## Department of Transportation

September 10, 2021

RE: Crossroads at Meadowbrook Mixed Use Preliminary Plan (11 Commercial Lots) -  
SH24G/SH94A EPC - SP2011

CROSSROADS AT MEADOWBROOK-MIXED USE PRELIMINARY PLAN

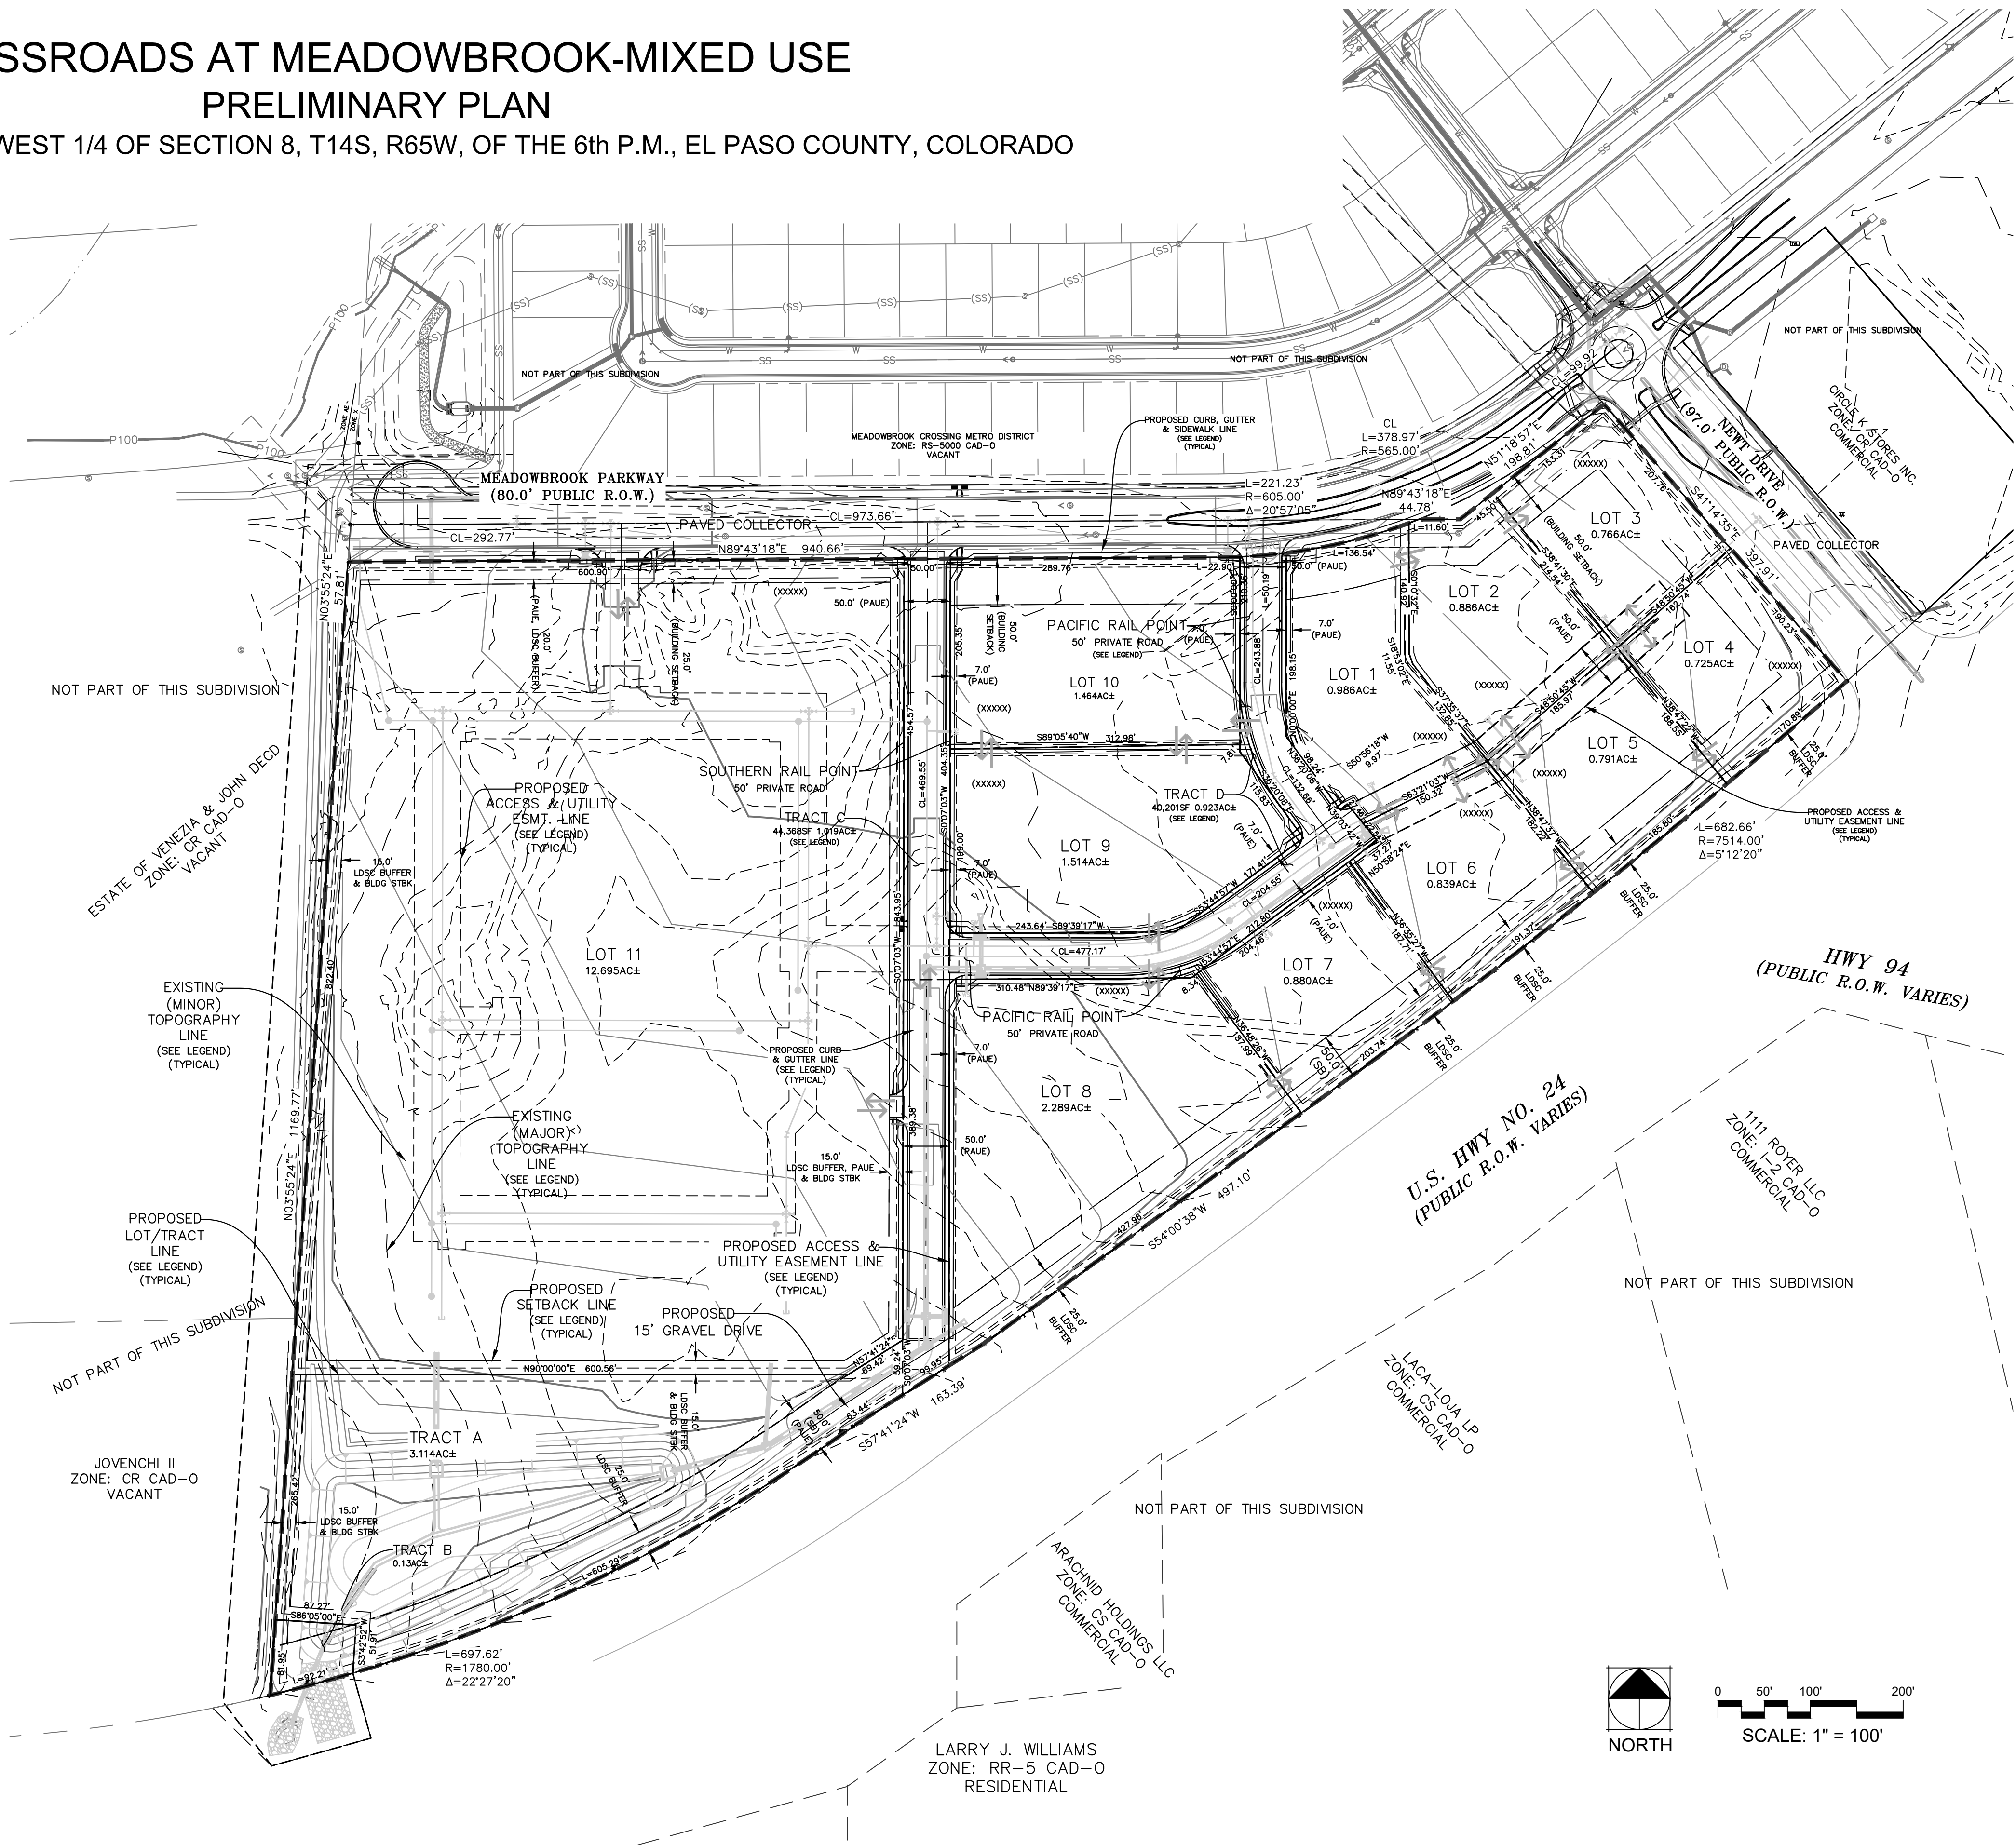
- Right-of-way shall be preserved for future interchange footprint at US 24 & Hwy 94 as shown in the PEL study.
- Future interchange improvements will impact most of lot 4, a significant portion of lot 5, and the landscape buffer of lot 6 and will need to be modified.

- No additional access will be allowed to the development from any of the surrounding State Highways and only allowed from the minor surrounding roadways.

CROSSROADS MIXED USE PROPOSED CONDITIONS DRAINAGE MAP

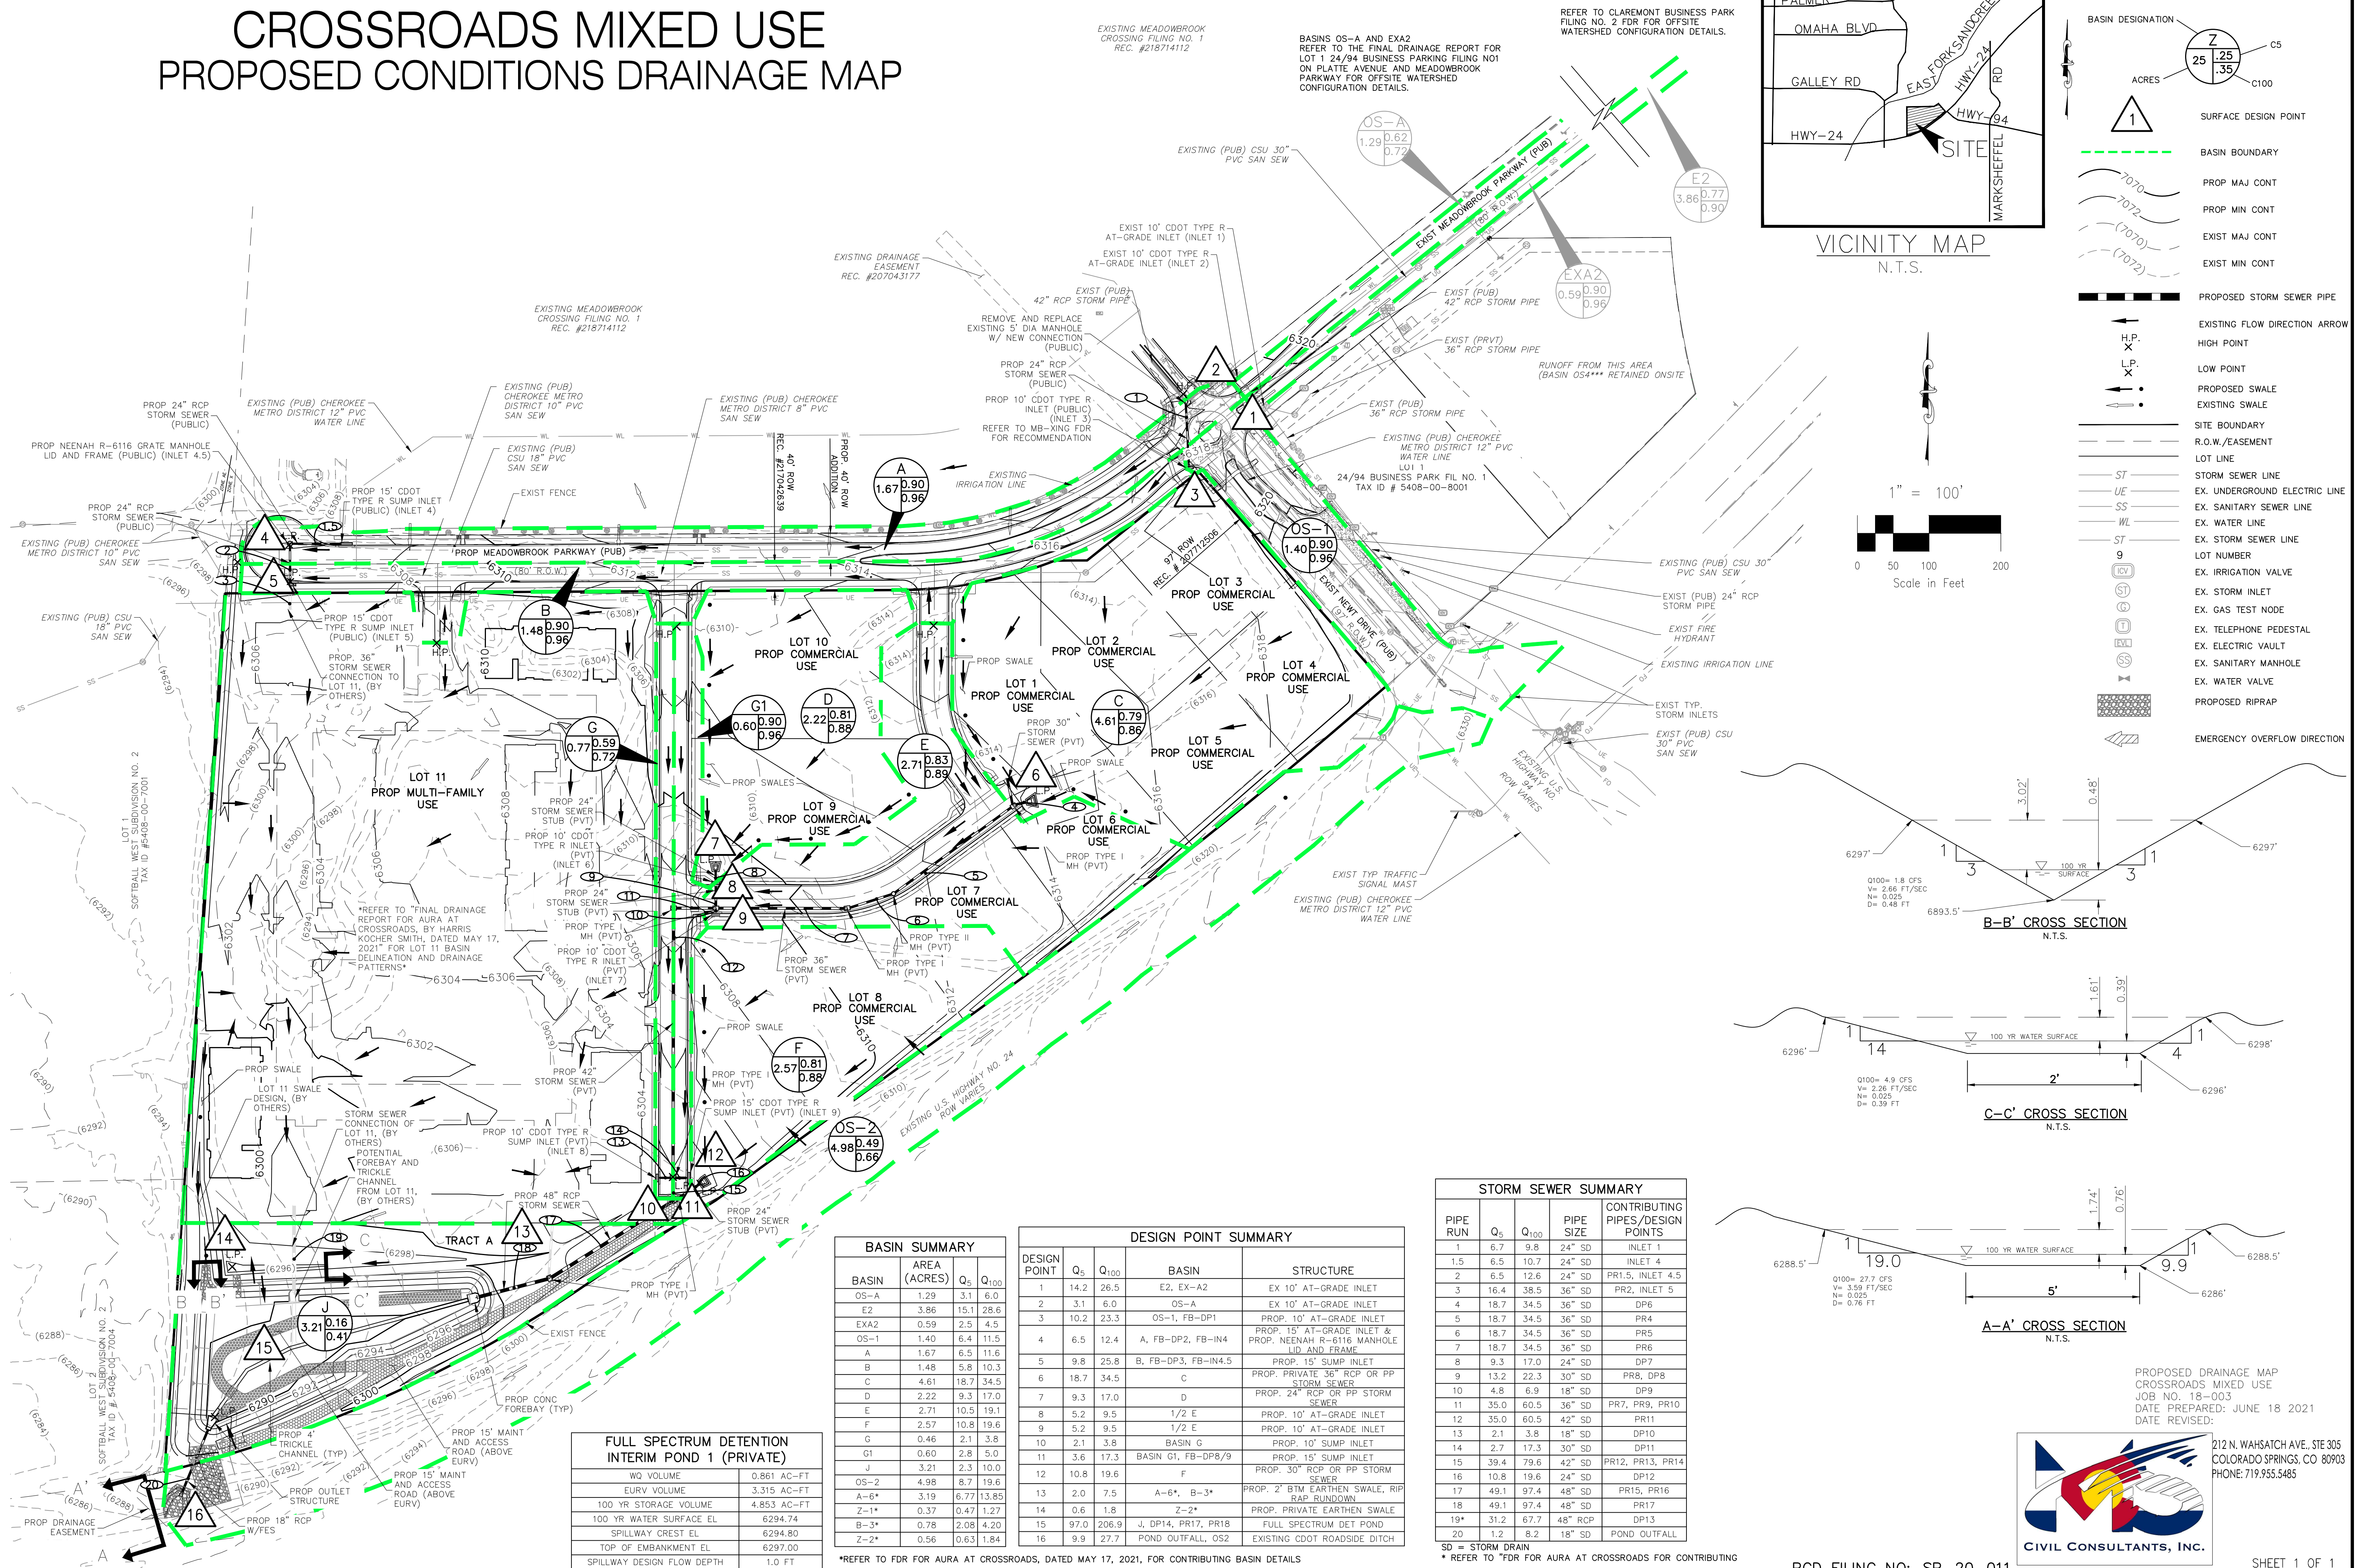
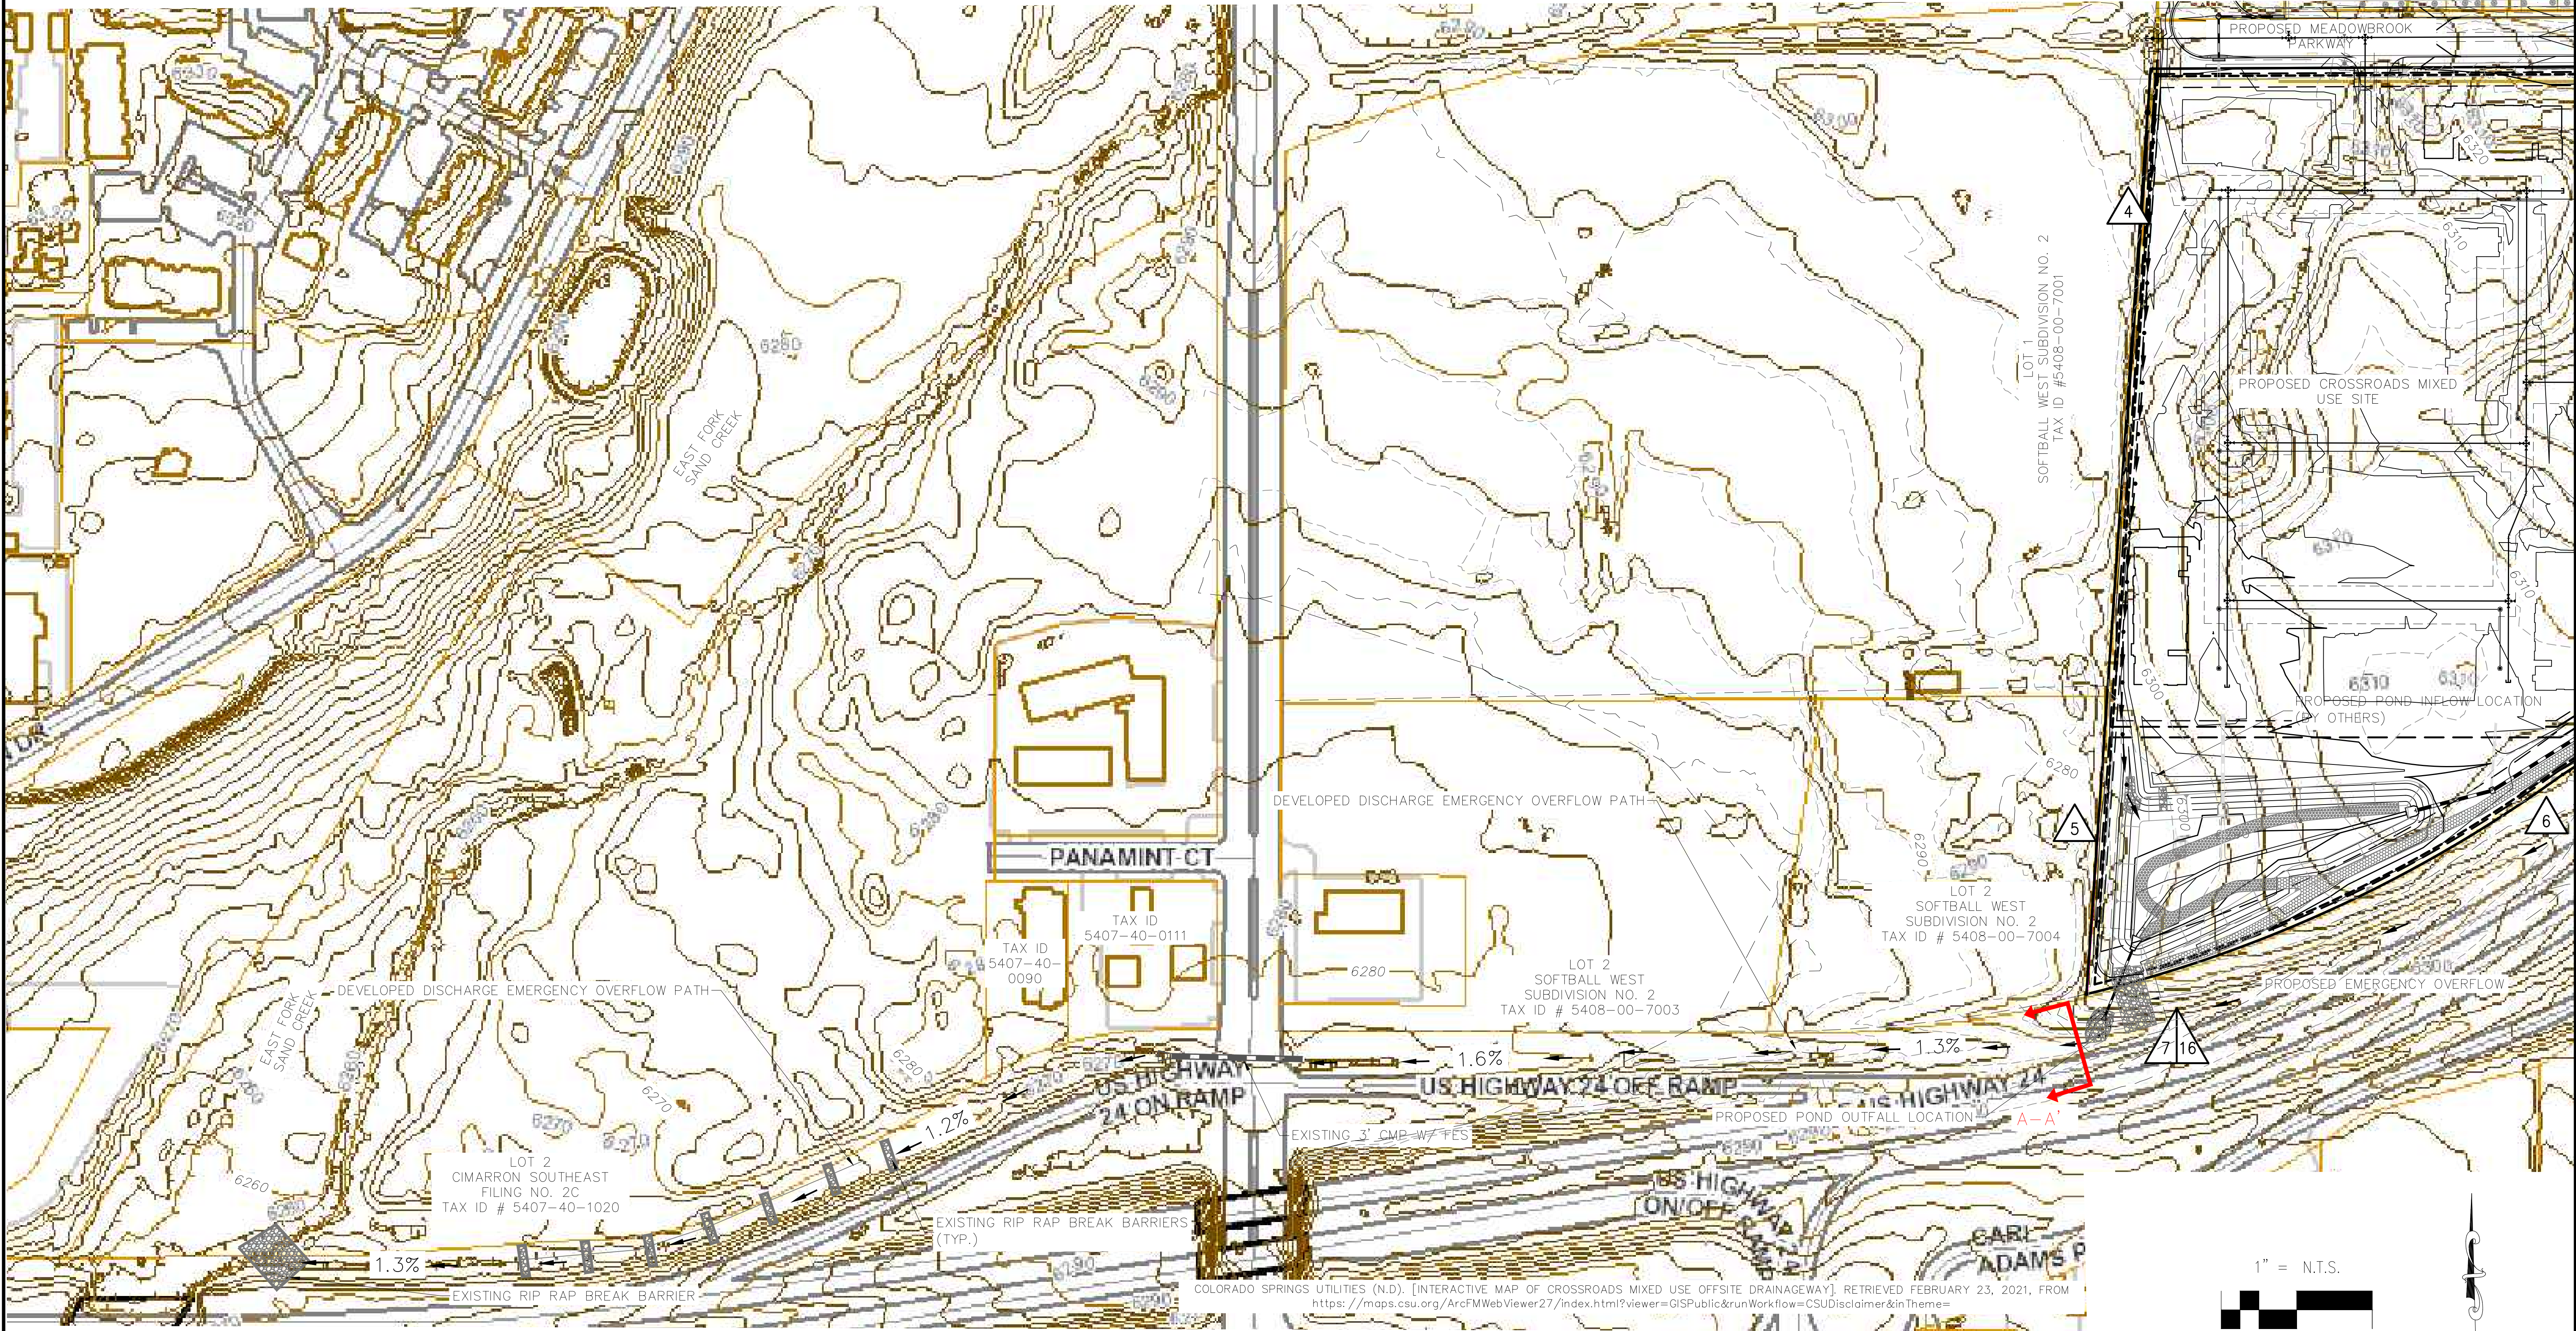
- January 11, 2021 comments: This project doesn't seem to directly affect CDOT facilities with the current design. My only concern is the outfall of the detention pond. The report states that the outfall discharges into an existing swale. This swale is not well defined. The existing condition is natural sheet flow across the basin and will be concentrated flow in the proposed condition at the outfall. In the final design, I would suggest the engineer ensure the swale can handle the concentrated flows without erosion of the channel bottom.

- March 24, 2021 comments: Existing conditions topo map shows that existing flow at the SW corner sheet flows to the west and that flow does not enter the existing roadside swale. The proposed detention pond outlet concentrates and directs this flow to the roadside swale, which will cause erosion. Please coordinate with CDOT Hydraulics Engineer to design suitable outlet protection.
